**Re: 25 Hotel Circle NE  
Traffic Impact Study, Draft  
HT#K21D015, Dated February 2021**

After review of the draft 25 Hotel Circle Traffic Impact Study dated February 2021 the City's Planning Transportation Development Review has the following comments and corrections.

Figure 5. Trip Distribution and Assignment

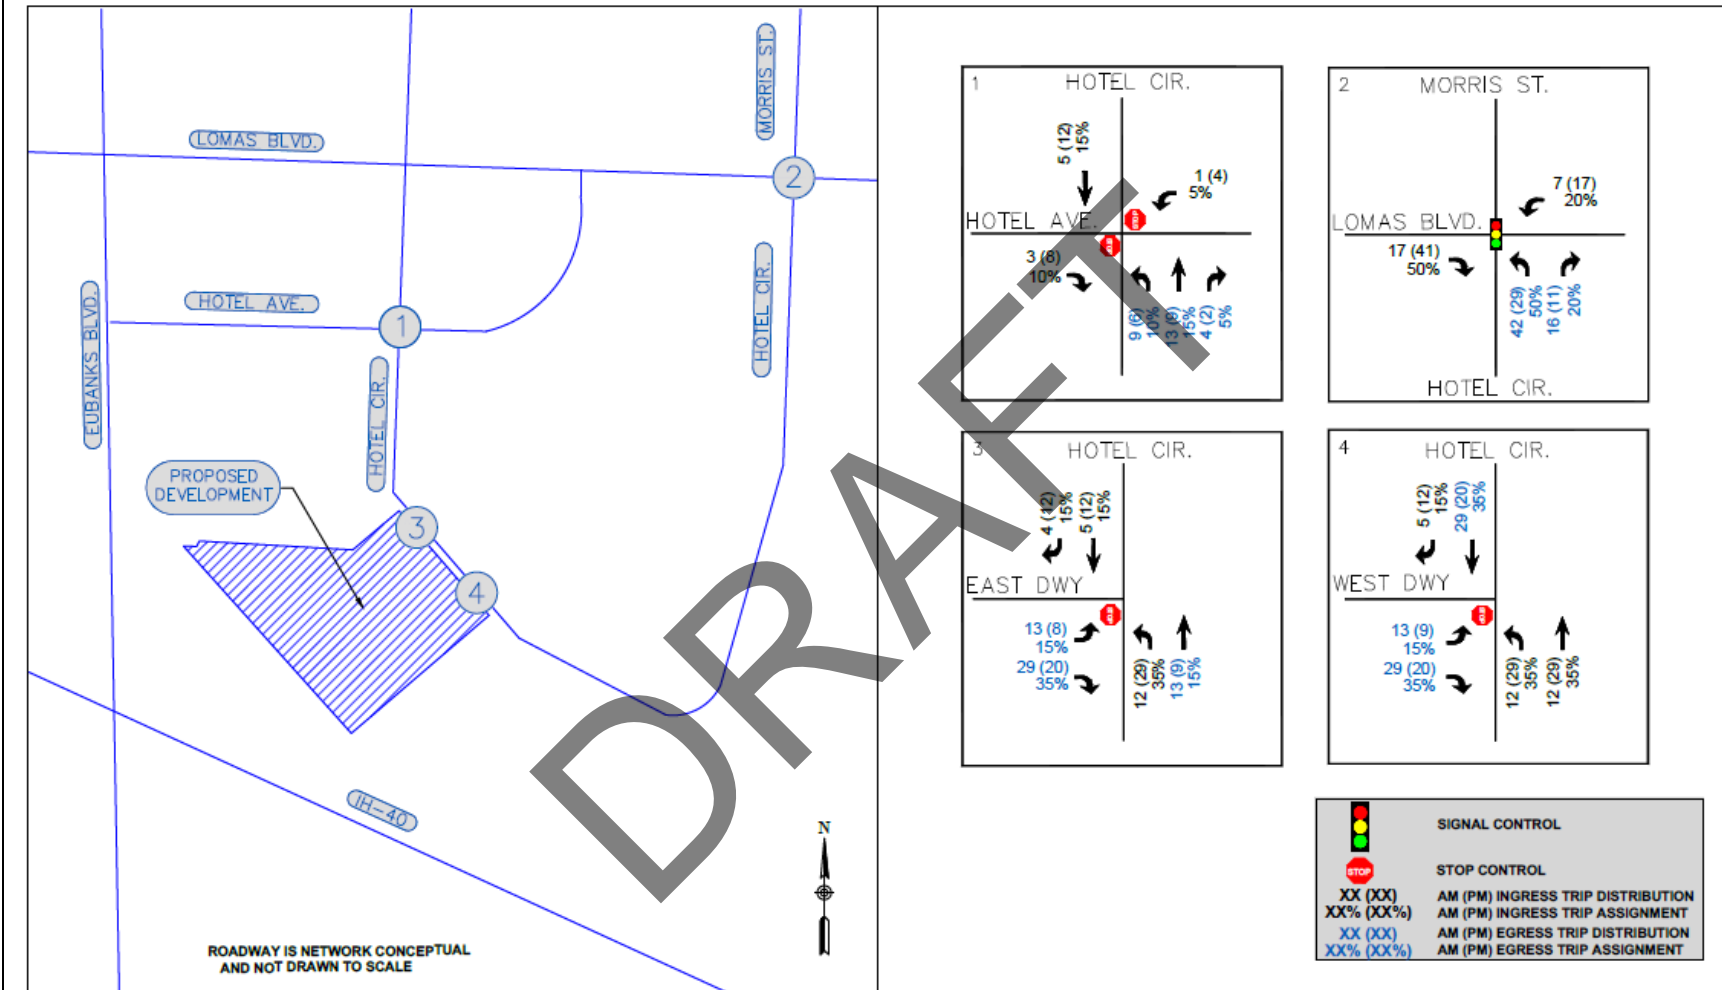
1. Reconstruct the west access to be 24 feet wide able to accommodate Solid Waste refuse vehicles. This driveway should be separated from currently shared driveway to the west.
2. Lengthen the left-turn lane striping for the northbound approach on Hotel Circle/Morris at Lomas. The turn lane should be 150 feet long plus the transition.
3. Correct the labeling of the east and west driveways in Turning Movement diagrams. The numbering of the driveways in the plan view don't match the turning movement diagram description.
